# CITY OF ALBUQUERQUE

April 1, 2011

**Re: The Boulders Phase 1 Subdivision Drainage Report and Grading and Drainage Plan**

**Engineer's Stamp date 3-11-11 (B11/D001B)**

EAST FLOOD WALL IN UNSER POND
TYPICAL SECTION
SC: NTS

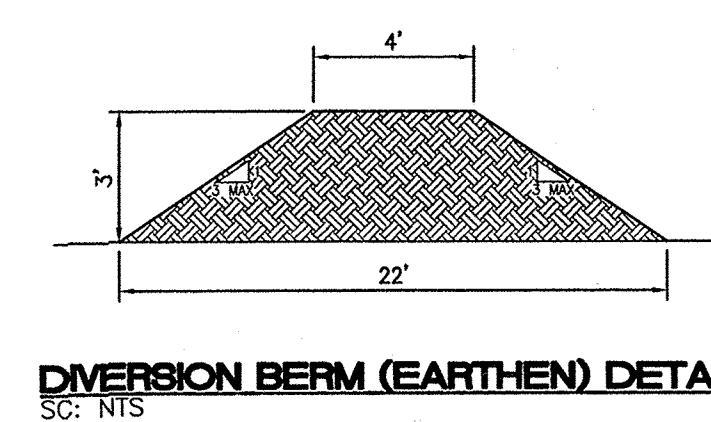
- Include the portion of Unser Blvd in the basin calculation table.
- The Volume Calculation table in the report shows the WSE at 5343 for 22.5 ac-ft. Finished Floor elevations east of the pond are around 5334 to 5346. It is not desirable to perch water 9 feet above adjoining houses.

THE BOULDERS PHASE 1 GRADING AND DRAINAGE PLAN		DRAWN BY DY
	TIERRA WEST, LLC 5571 MIDWAY PARK PLACE NE ALBUQUERQUE, NM 87109 (505)858-3100 tierrawestllc.com		DATE 05-06-11
			2011005-SH01-02- GRE-PH1
			SHEET # 7

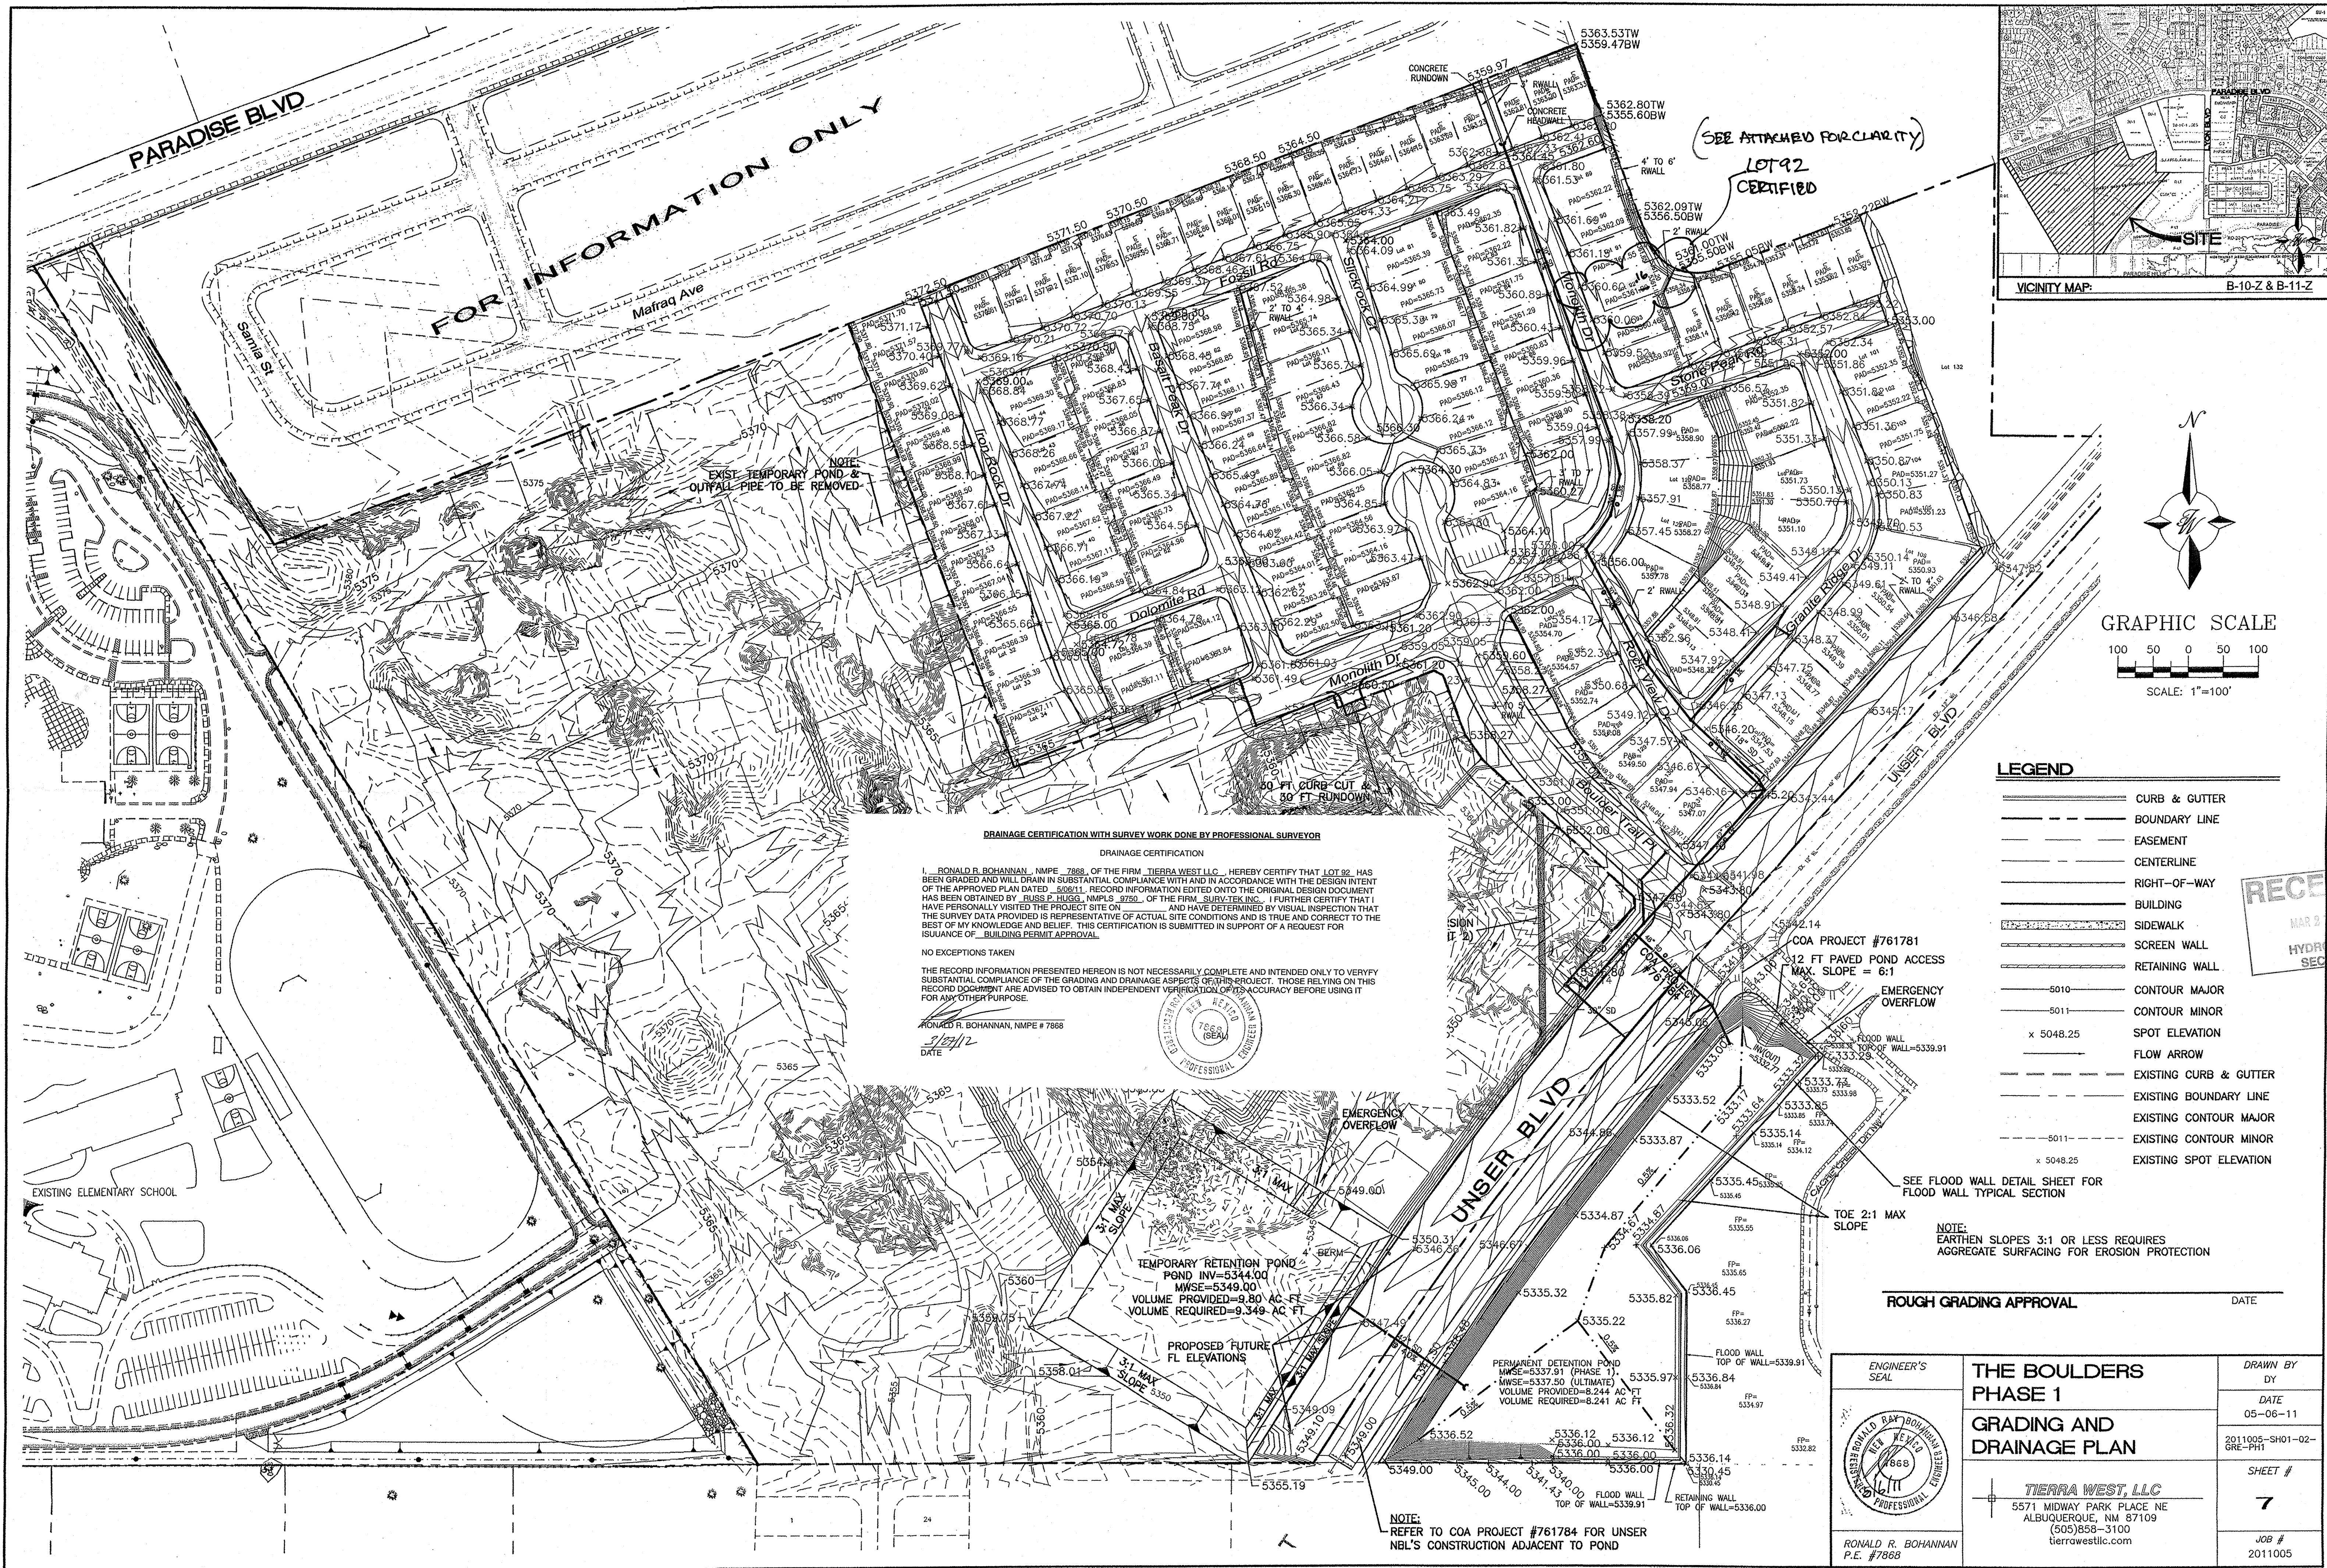
- Please provide a Grading and Drainage Plan on a larger scale 1"=40' or similar where the houses are and the adjacent area.
- Please state when you expect (Phase) to drain the Chamisa Storm Drain to the Unser Pond.

- The 48" RCP in Unser Blvd is shown as existing. Please provide the City Project Number that it was built with.
- Provide flow line elevations or a profile for Unser Blvd fronting this development.

- Provide the Volume Required, Volume Provided and Water Surface Elevation for the Unser Pond for Phase I on the grading plan and for all three phases in the drainage report.

- Your retaining wall line work should match the legend.
  - It appears from reviewing the church grading plan that retaining walls will be required on the south side of the church lot. *church changing of water run wall*
